From: Paul Cann
Sent: 18 December 2017 13:37
To: Planning.Responses
Subject: RE: Planning Consultation on Y/87/17/DOC

APPLICATION Y/87/17/DOC
NO:

Registered: 27-NOV-17
Site Address: 14 Gladstone Road Yapton BN18 0JP

Description of Approval of details reserved by condition imposed under
Works: Y/38/17/HH relating to condition 4-surface water drainage.

Client	Mr and Mrs Connington
Drawing Title	Surface Water Drainage

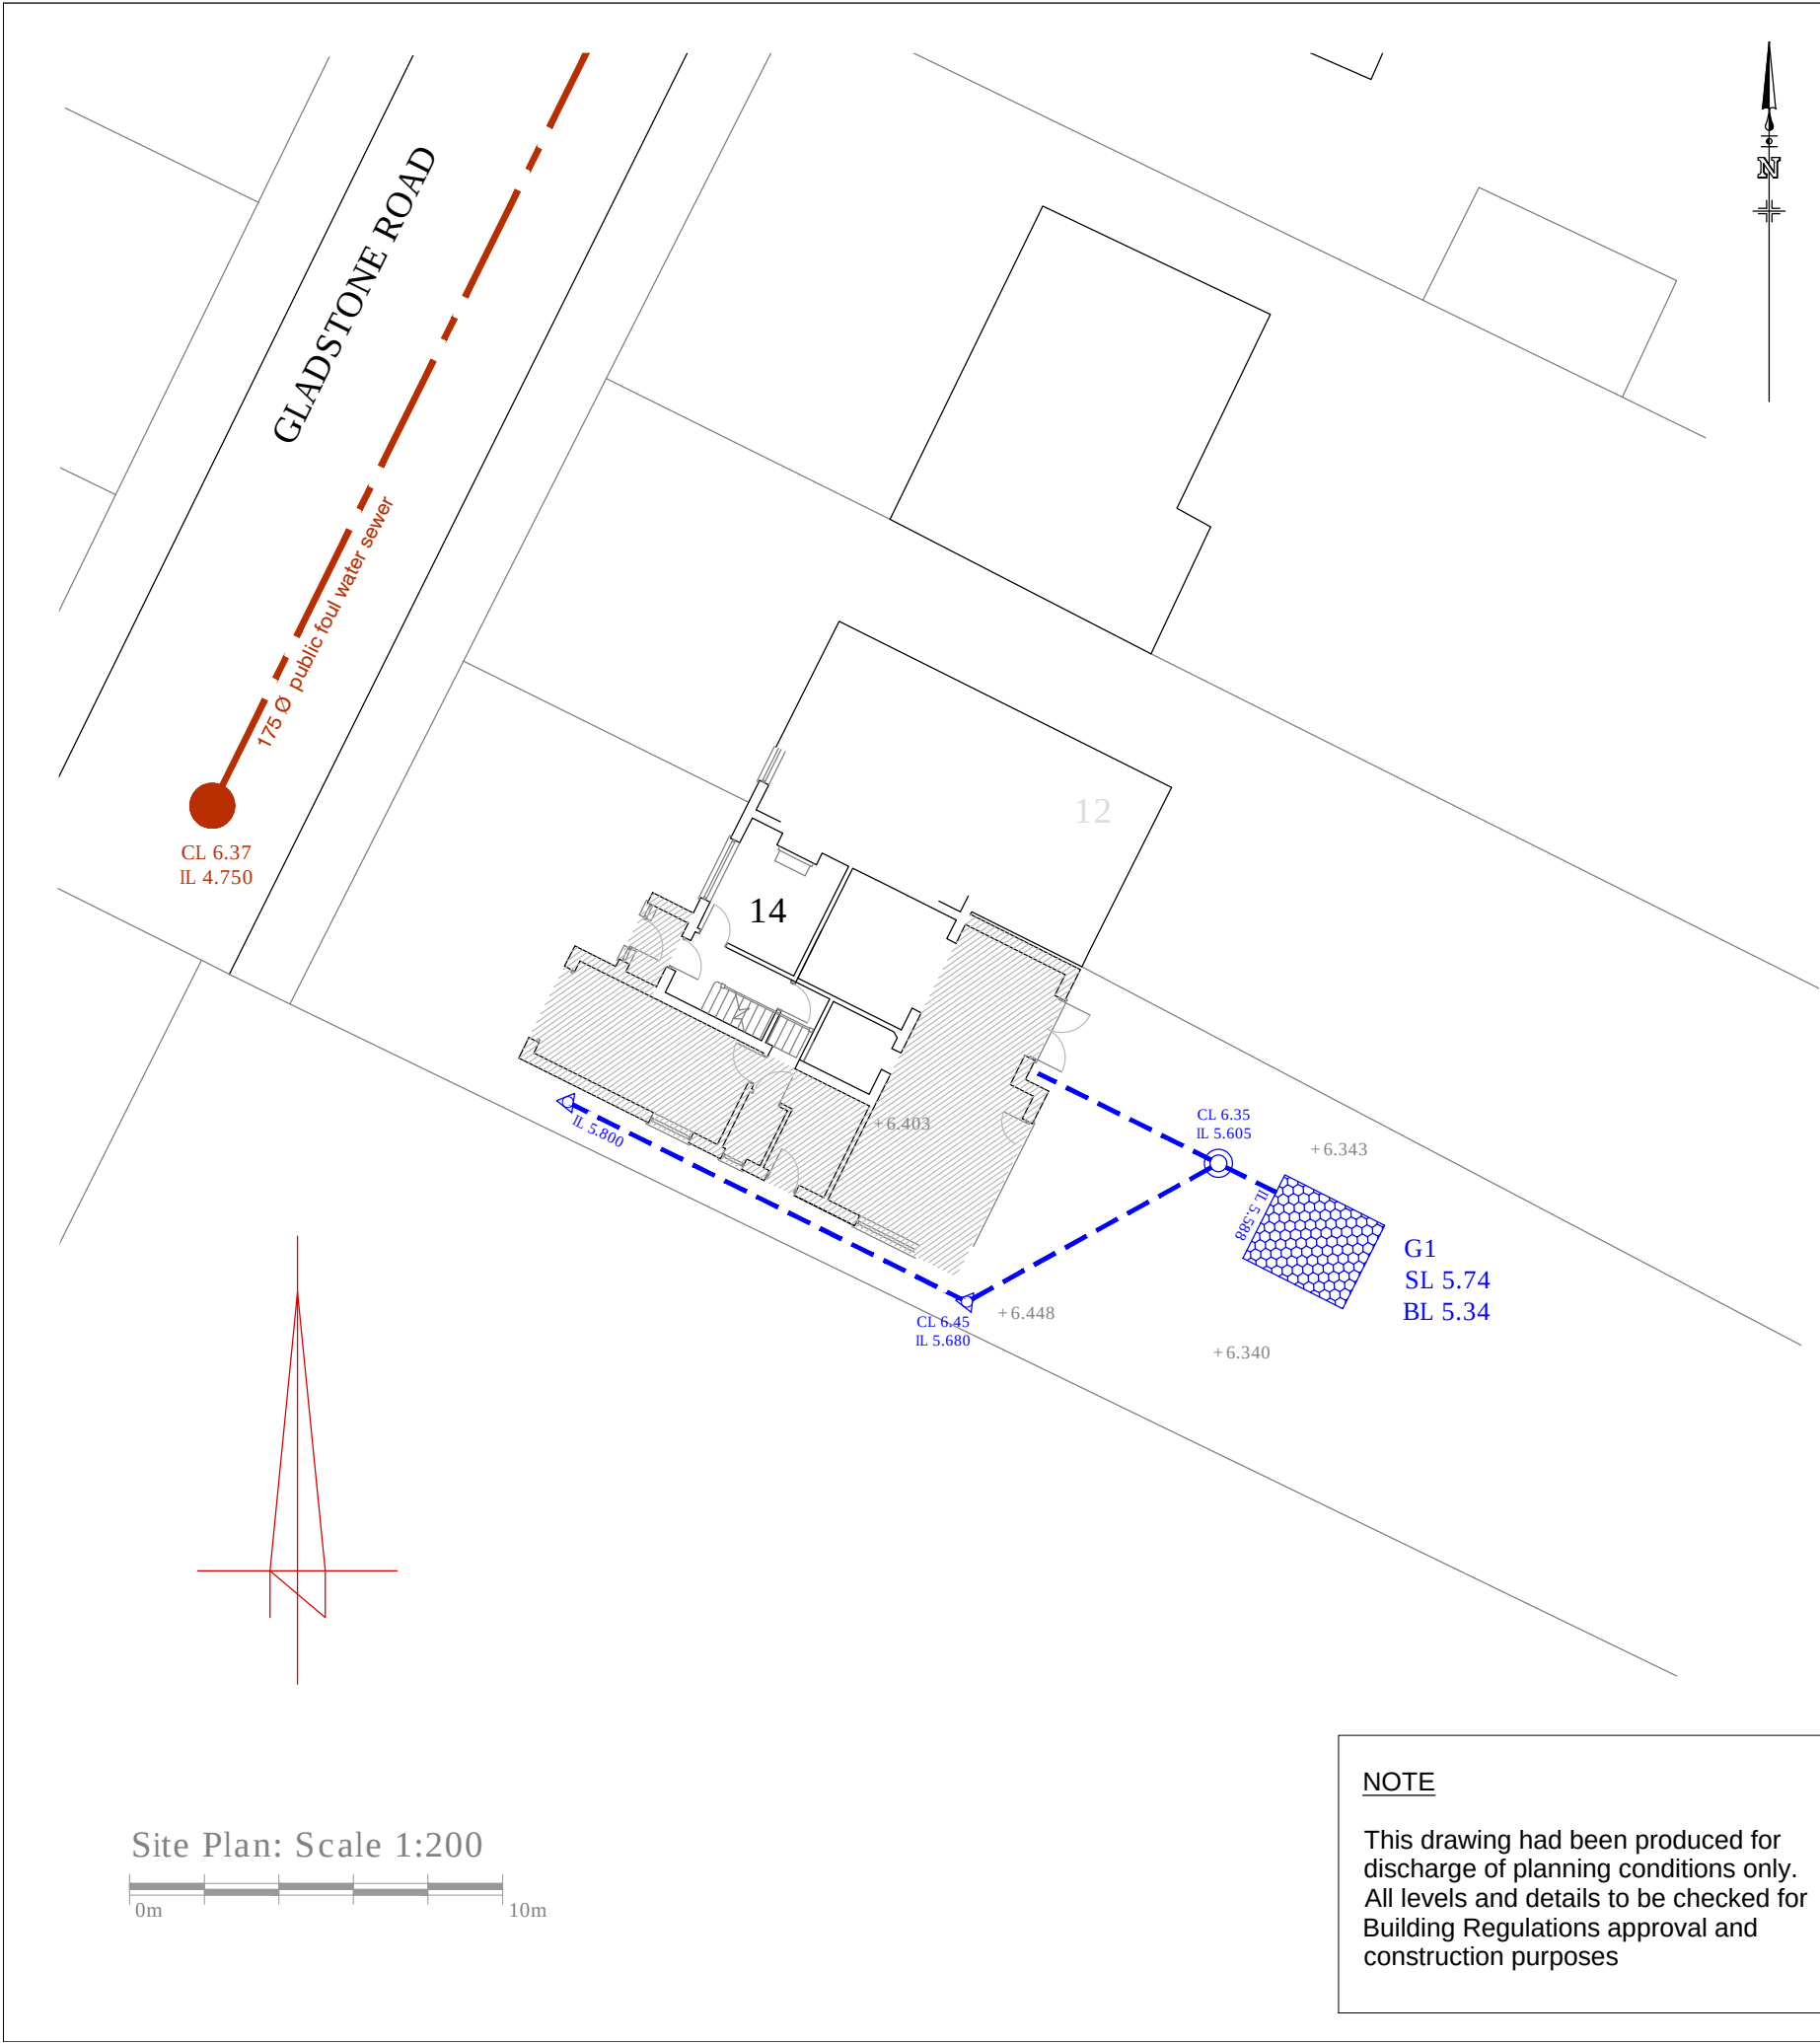
It is noted that the groundwater monitoring/percolation testing was not carried out an agreed time during the winter period ie. with a view to capturing worst case conditions.

However, in this instance, primarily due to the site locality and known ground conditions, the depth of the water table observed at the time, the proposed depth of the proposed soakaway and the safety factor applied to the percolation rate, the proposals will be acceptable.

The condition can therefore be discharged.
